**RE: Response Letter Regarding
Site Development Plan Comments for the
Stratmoor Hills Water District Centralized Water Treatment Project**

This letter is being provided with submittal of the revised Letter of Intent, Landscape Plan, Lighting Plan, Site Development Plan, and PBMP Applicability Form for the Stratmoor Hills Water District Centralized Water Treatment project identified above. The comments received by the review agencies are outlined below, along with responses regarding requested information.

STRATMOOR HILLS WATER DISTRICT - CENTRALIZED WATER TREATMENT

SITE DEVELOPMENT PLANS
LOT 2, GLENARM SUBDIVISION FILING NO. 2

CENTRALIZED WATER TREATMENT
GRADING AND EROSION CONTROL DETAILS

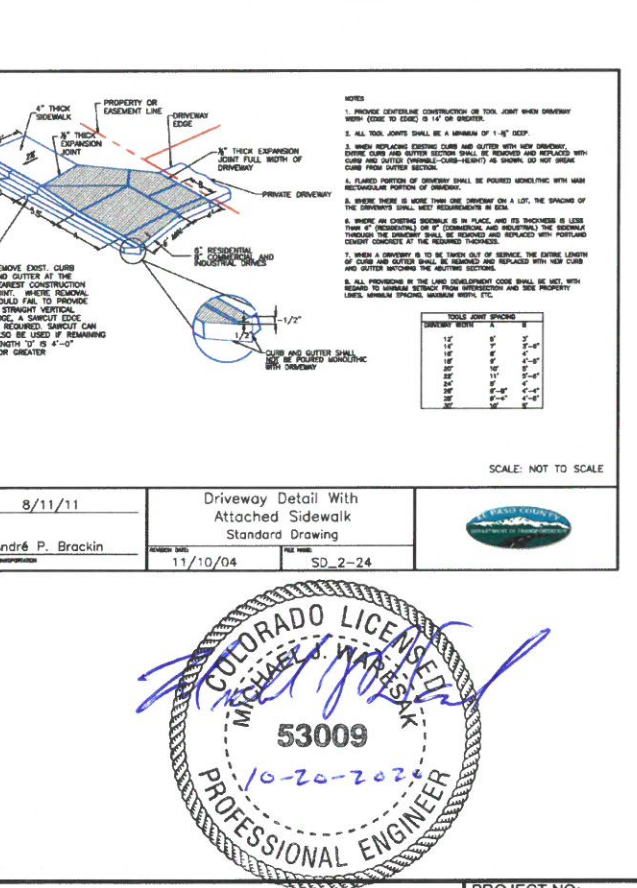
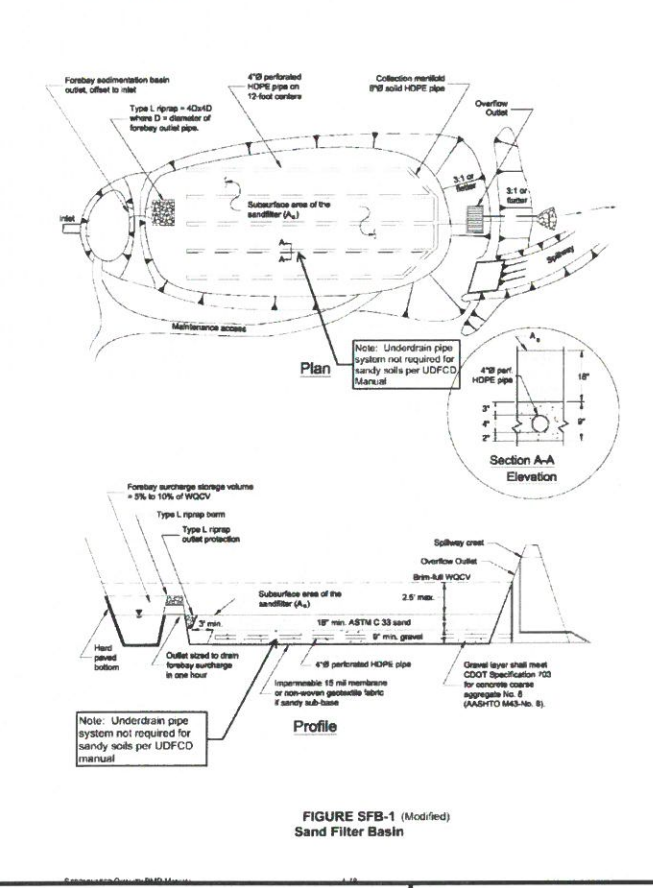
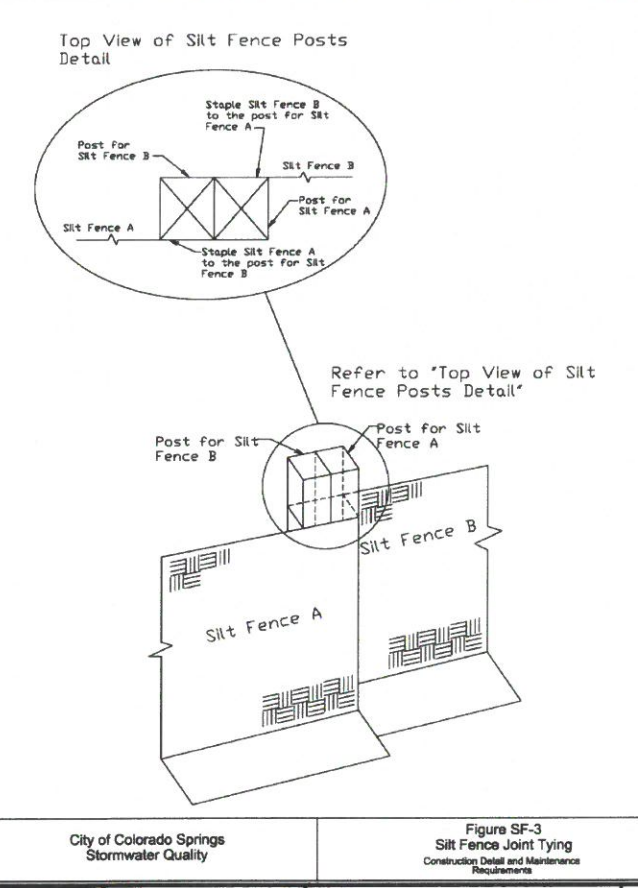
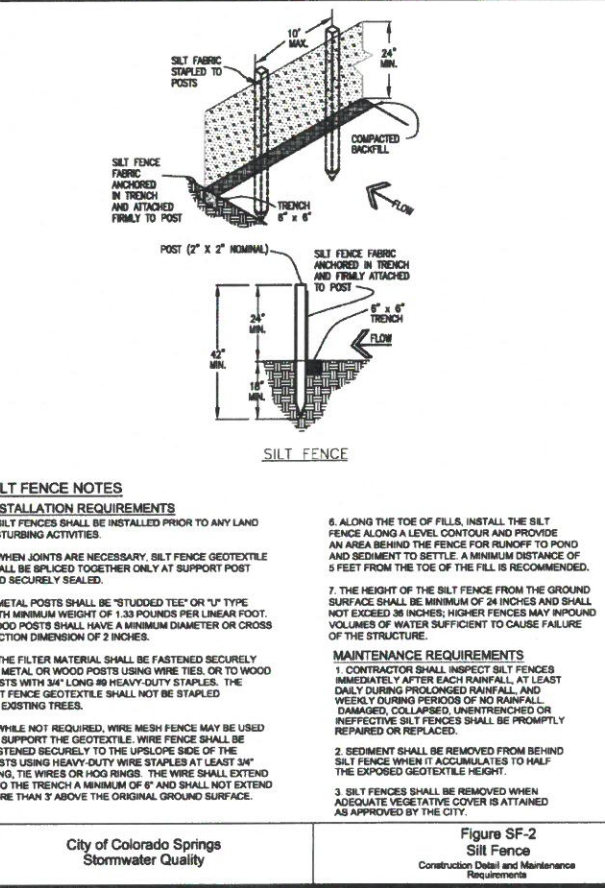
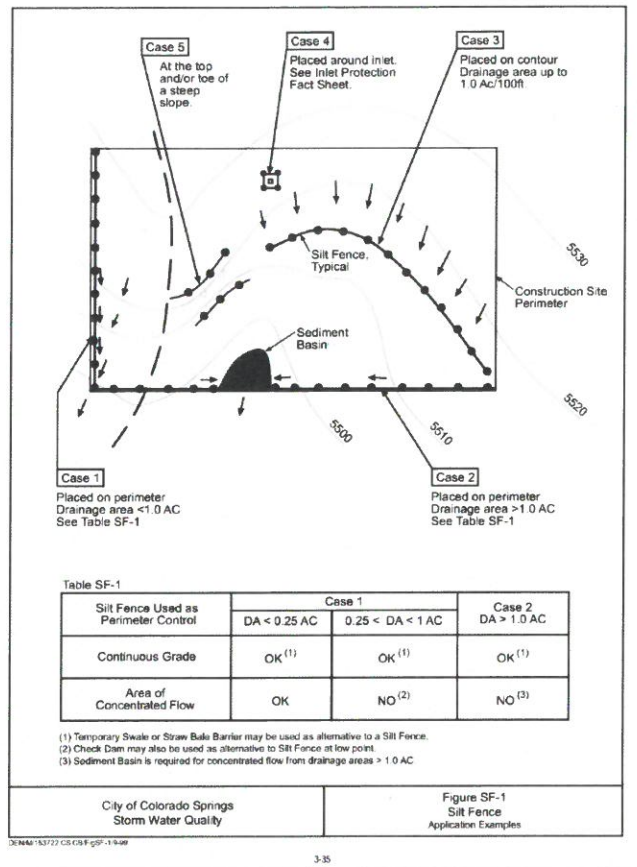
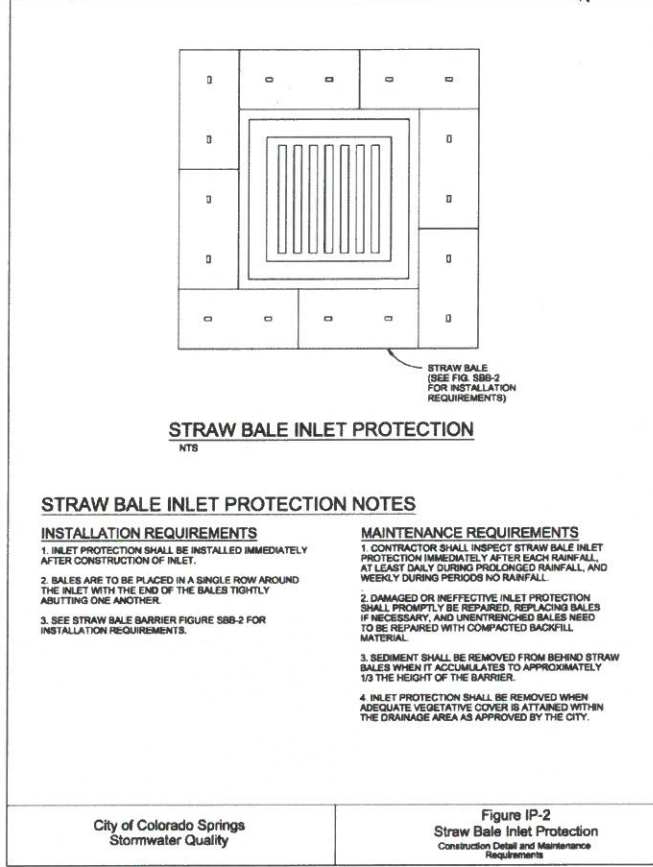
Please provide construction documents to show the proposed grading and the proposed sand filter basin.”

Sand filter basin and grading construction requirements and details are included on the Grading and Erosion Control Plan and Grading and Erosion Control detail sheets.
